Drexel, Barrell & Co.

December 1, 2021, Revised February 11, 2022

Re: Falcon Marketplace Filing No. 1
Request for reimbursement of Major Drainage Improvements
Falcon Drainage Basin

**STORM SEWER
PLAN &
PROFILE**
PROJECT NO. 20988-00CSCV
DRAWING NO.
C7.1
SHEET: 8 OF 27

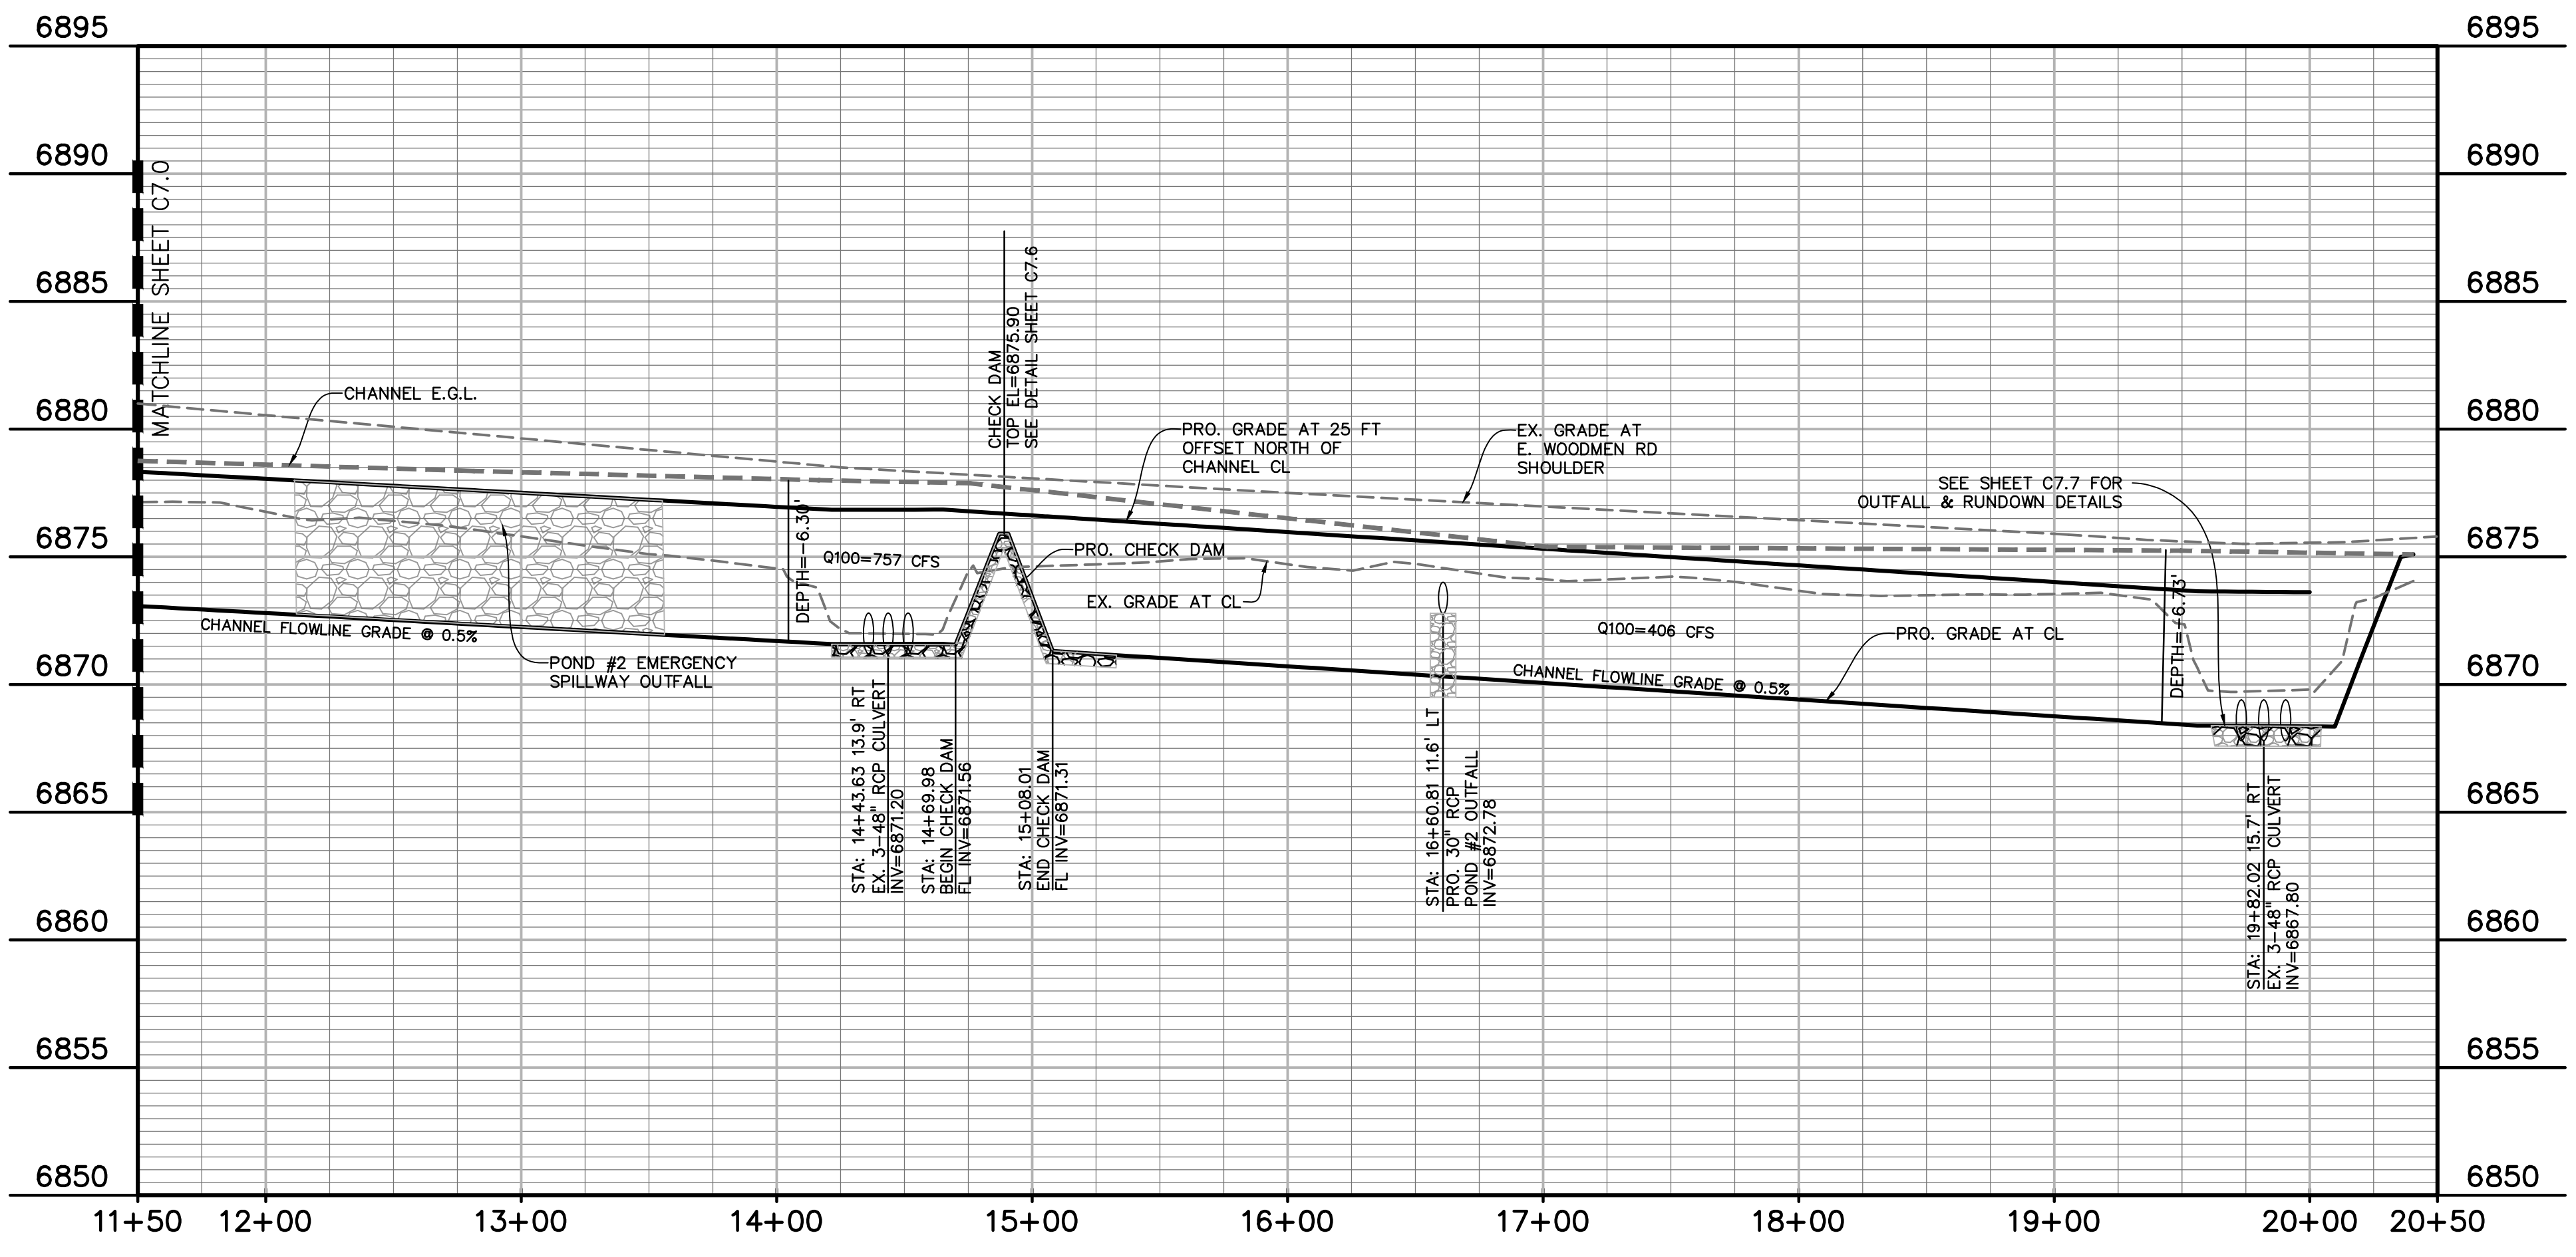
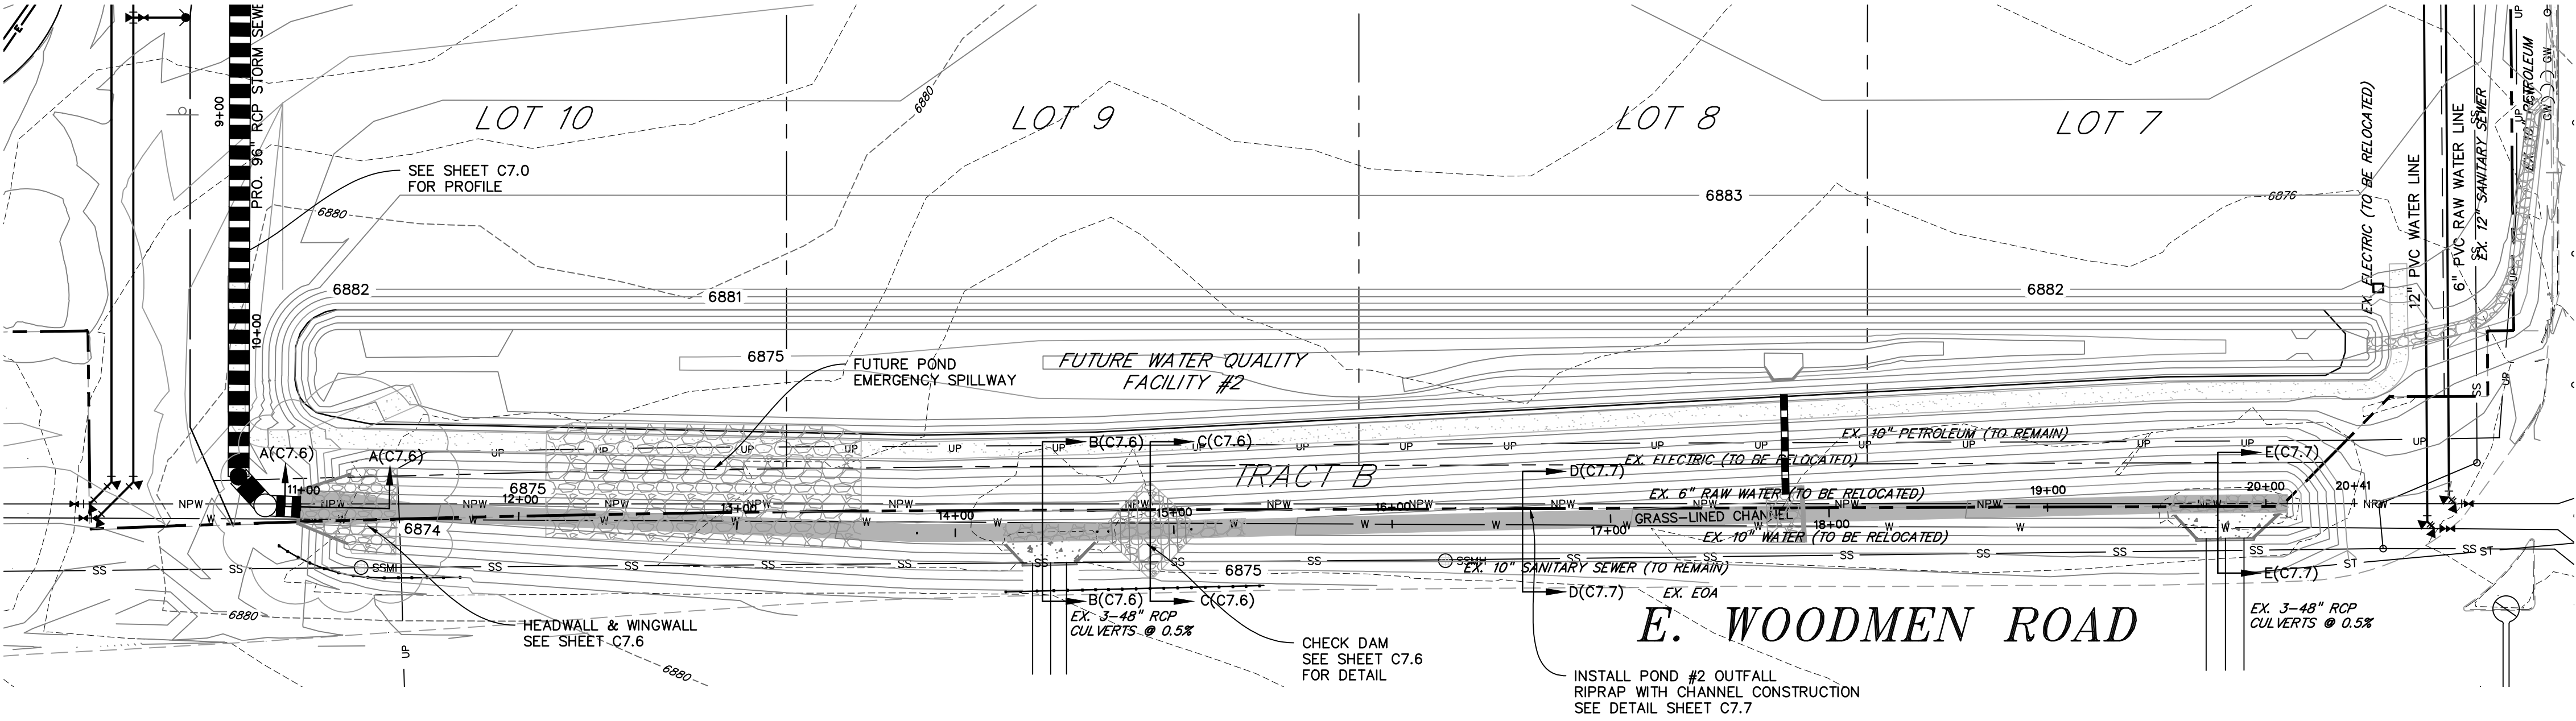
Justify reimbursement request for the channel. A roadside ditch to convey runoff from the 96" RCP would have been constructed regardless of the culvert improvement. This is also a result of the over-detention design of the pond to the north. Land value should only be the additional width from a v-ditch
